DEPARTMENT OF PARKS AND COMMUNITY SERVICES

November 2, 2023

Subject: Overlook at Homestead Preliminary Plan (SP238)

PERLIMINARY GRADING PLAN NORTH

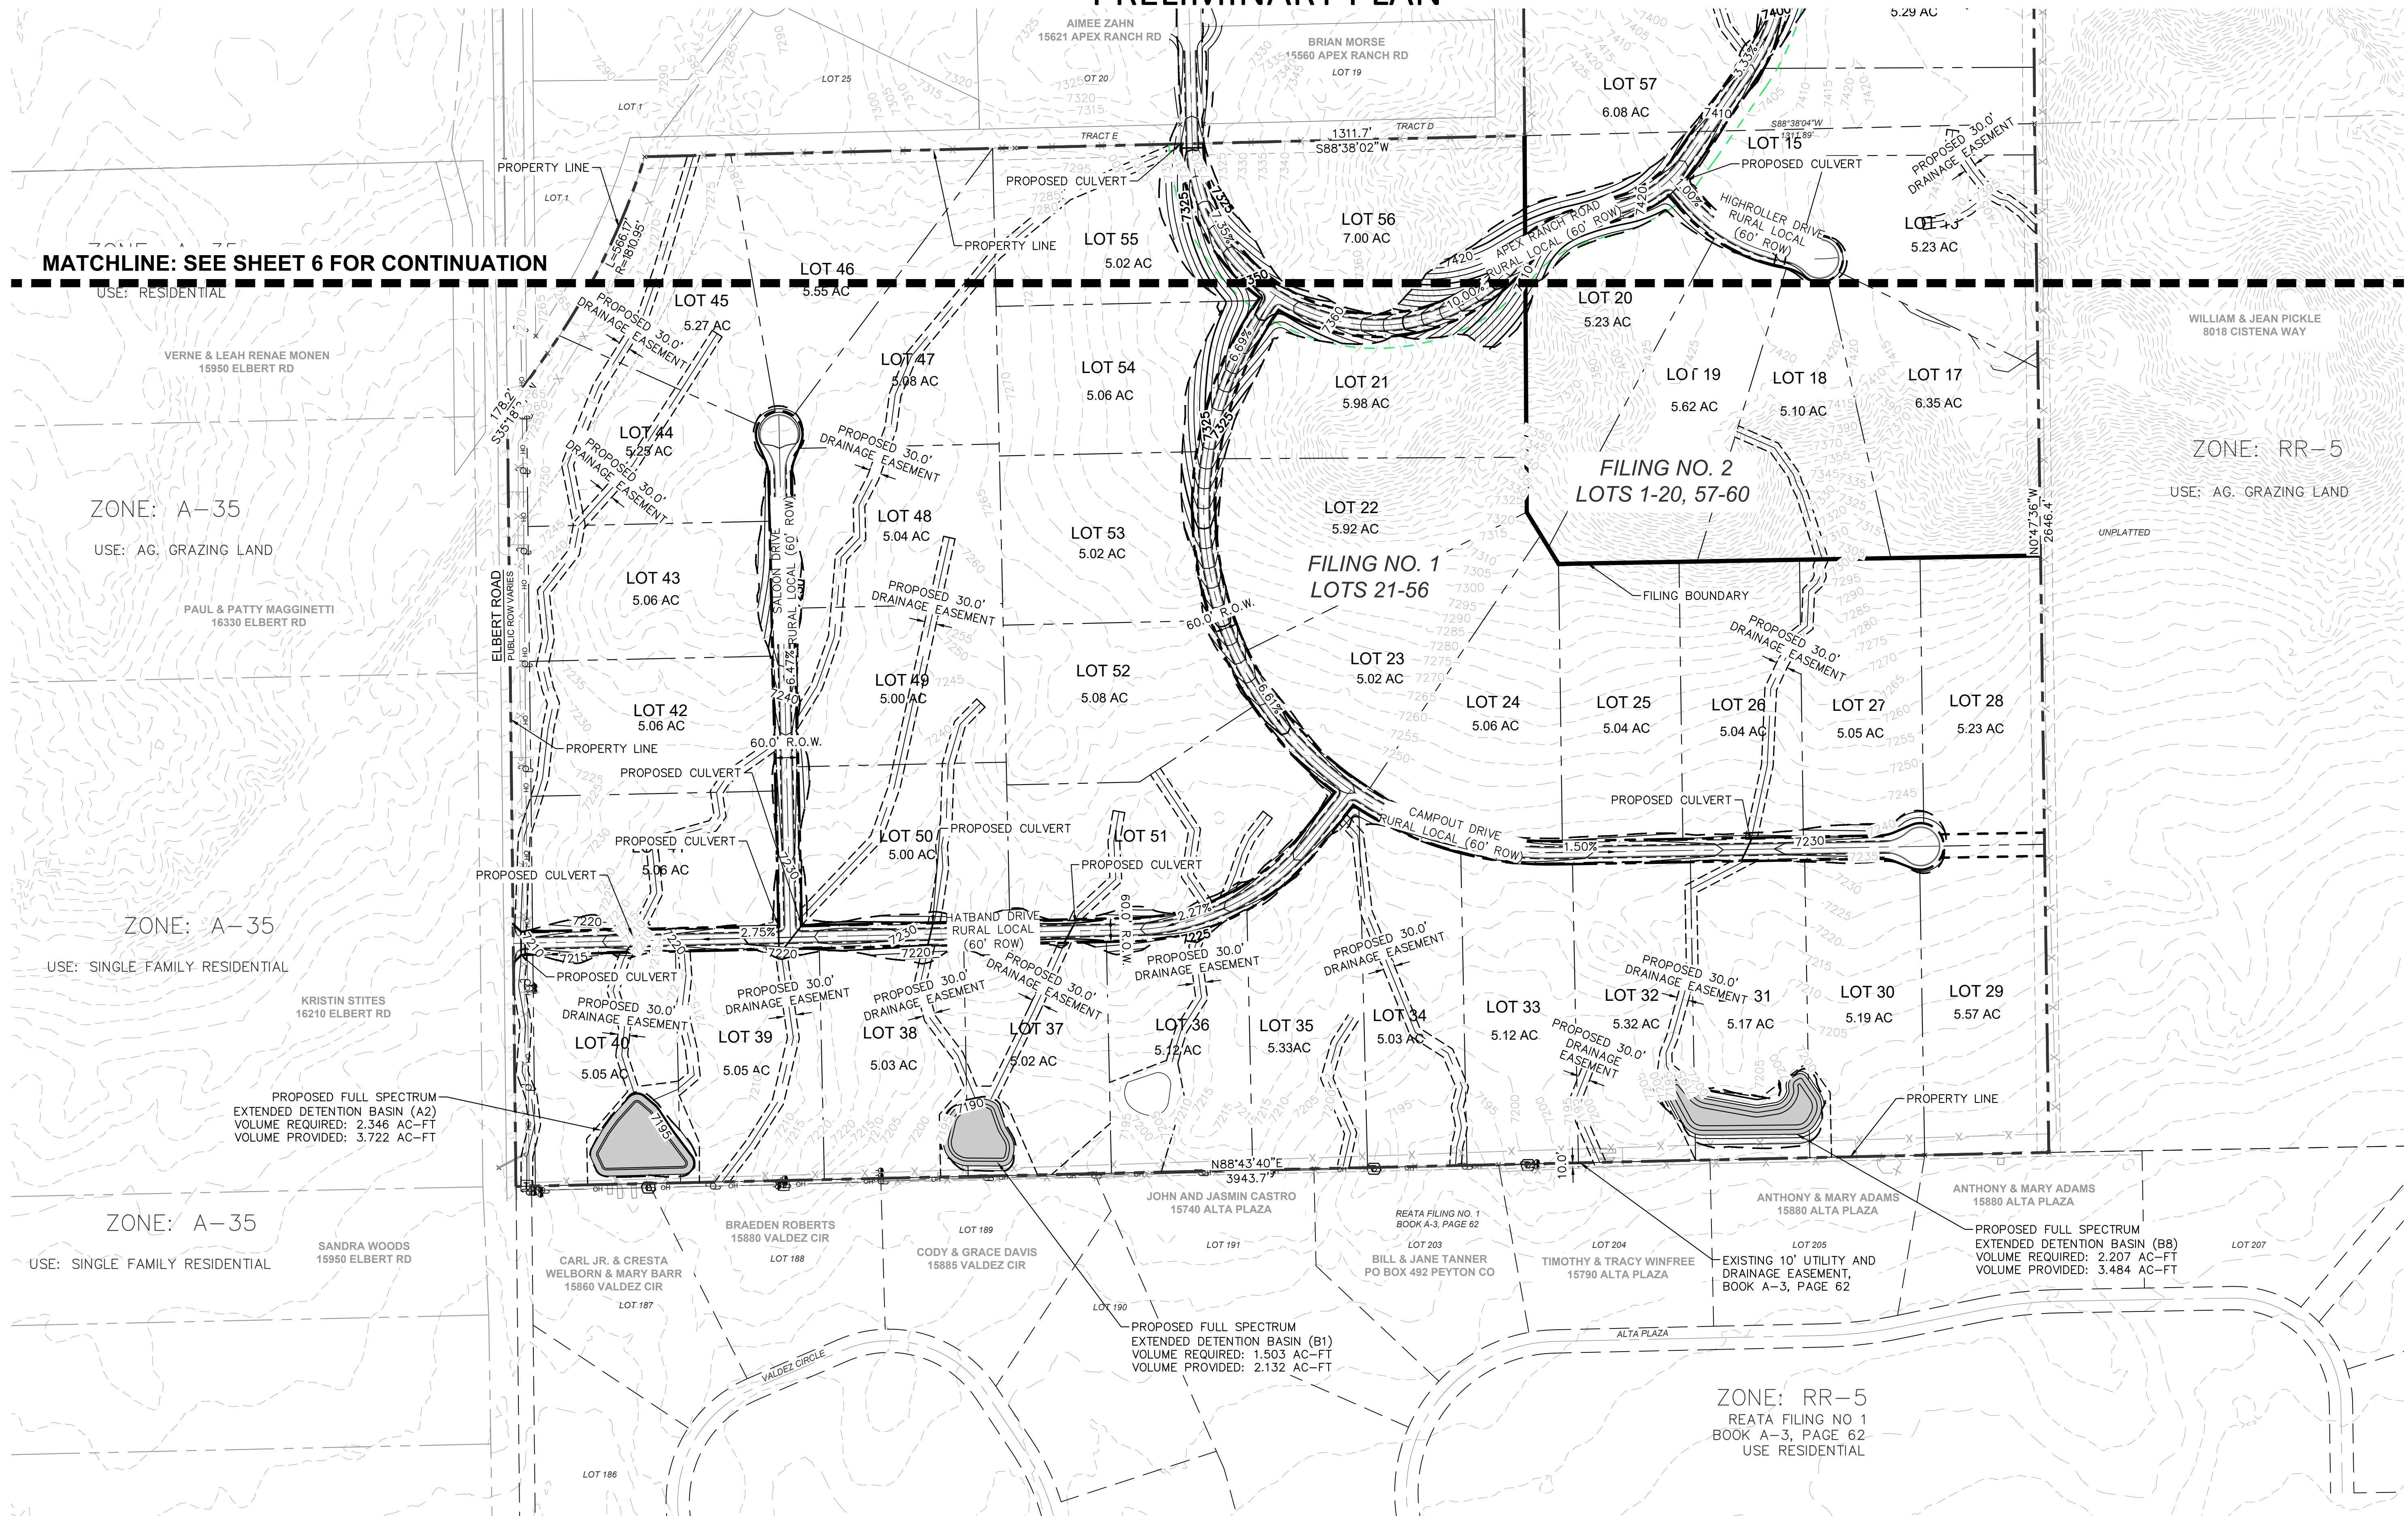
Additionally, County Parks requests that the Palmer Divide Regional trail be graded when the subdivision is constructed so that the trail can be built in the future. As the applicant's grading plan currently shows, although preliminary, grades for a trail along the proposed alignment would not be possible once tied into existing grades on private property outside the trail corridor. It would be best to grade the trail into the hillside when the roads and lots are developed to avoid grading beyond the trail easement in the future.

Recommend that the Planning Commission and the Board of County Commissioners include the following conditions when considering and/or approving the Overlook at Homestead Preliminary Plan: (1) fees in lieu of land dedication for regional park purposes in the amount of \$31,310 will be required at time of the recording of the forthcoming final plat. A Park Lands Agreement may be an acceptable alternative to urban park fees provided the agreement is approved by the County and executed prior to recording the forthcoming final plat; (2) provide a 25-foot public trail easement along the Palmer Divide Regional Trail alignment that allows for the construction and maintenance by El Paso County of the Palmer Divide Regional Trail, and this easement shall be shown and dedicated to El Paso County on the Final Plat. (3) County Parks requests that the Palmer Divide Regional Trail be graded when the subdivision is graded to allow for the construction of the trail in the future.
